Comment re. side-facing ground-floor window/opening — Plot 23, application 2026/91657

I wish to raise a specific concern regarding the apparent side-facing ground-floor opening/window on Plot 23.

Side/north east facing elevation (1:100)

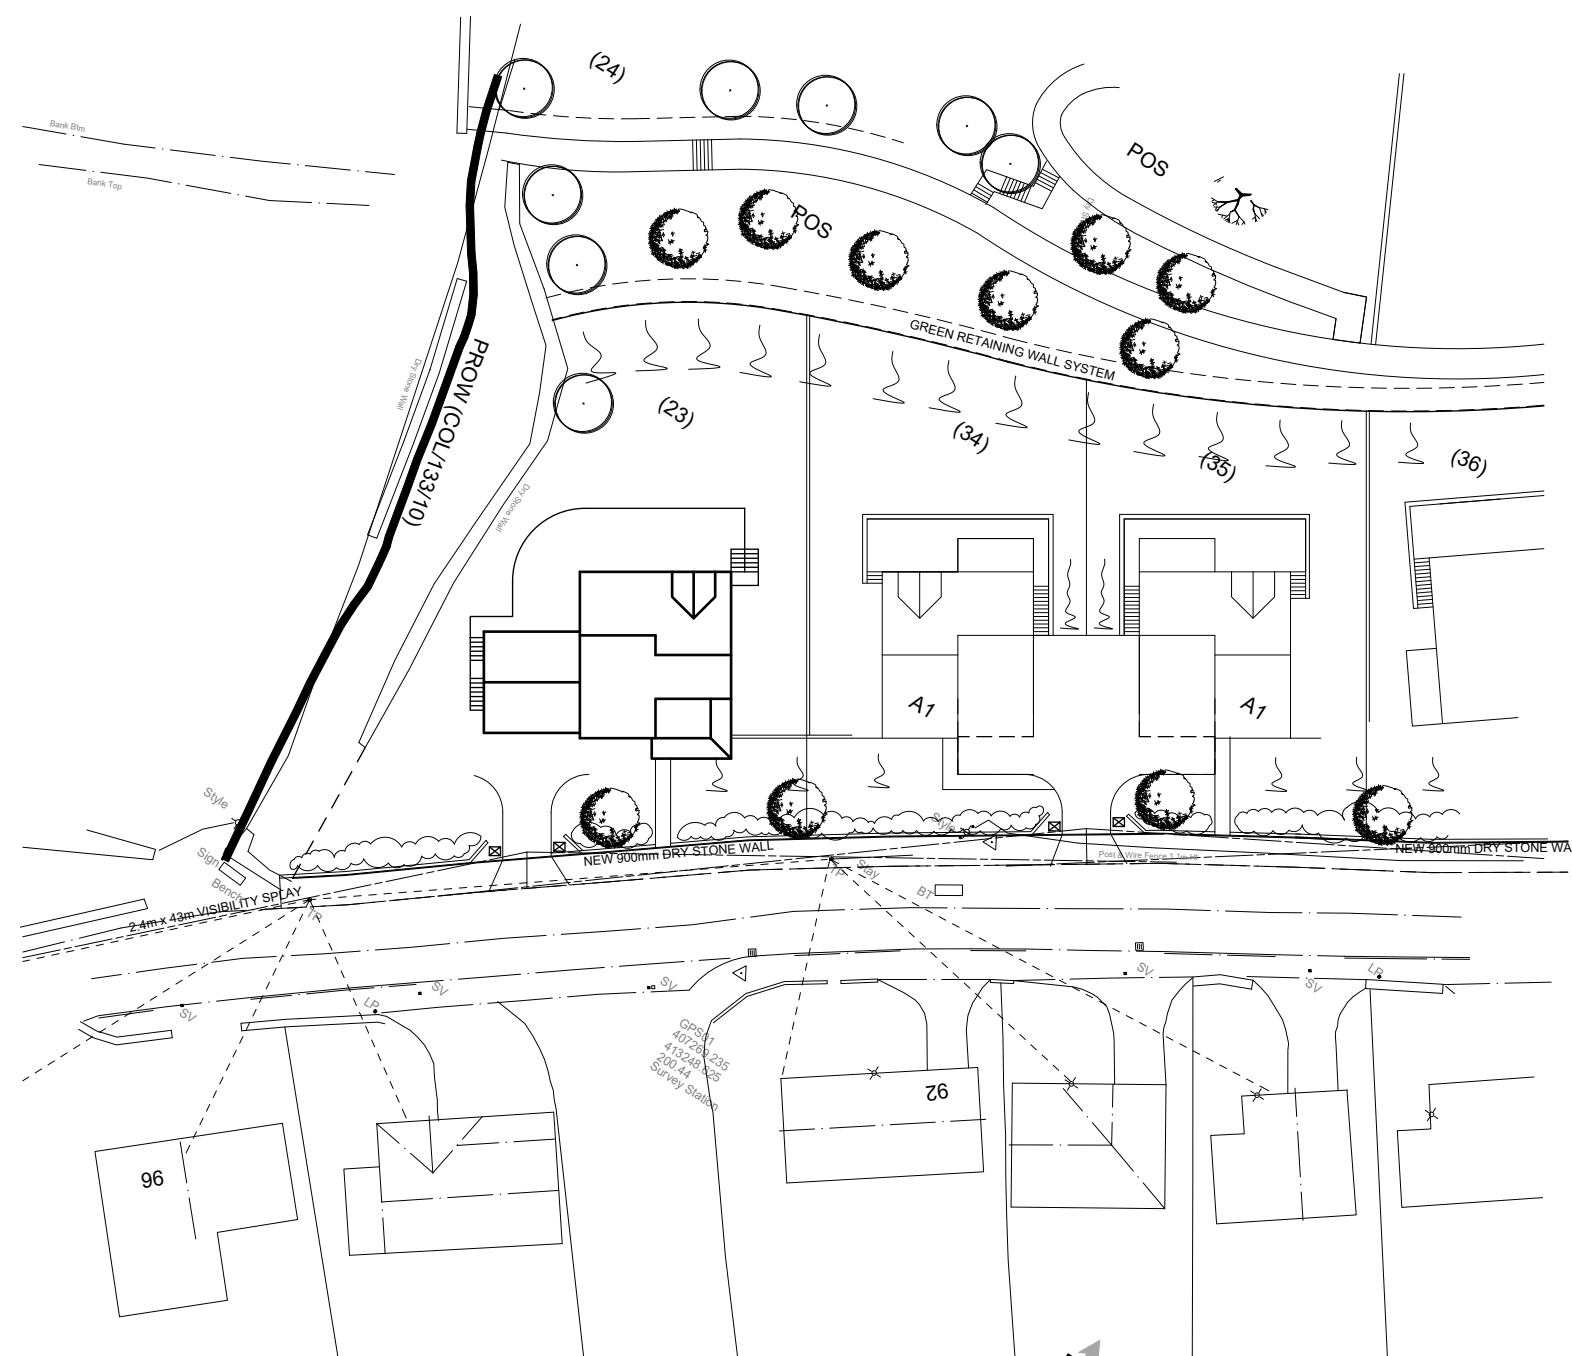
The approved/submitted side elevation for Plot 23 shows no ground-floor window on the same side elevation as the glazed stairway / side element. The elevation appears to show a blank wall in that position.

However, recent site photographs appear to show Plot 23 being constructed with a ground-floor side opening/window position on that elevation. This does not appear to correspond with the submitted elevation drawings.

The concern is not simply that a side-facing window exists. The concern is that the approved drawings for Plots 23, 34 and 35 do not appear to show these windows, yet Plots 34 and 35 have been constructed with them and Plot 23 appears to be following the same pattern.
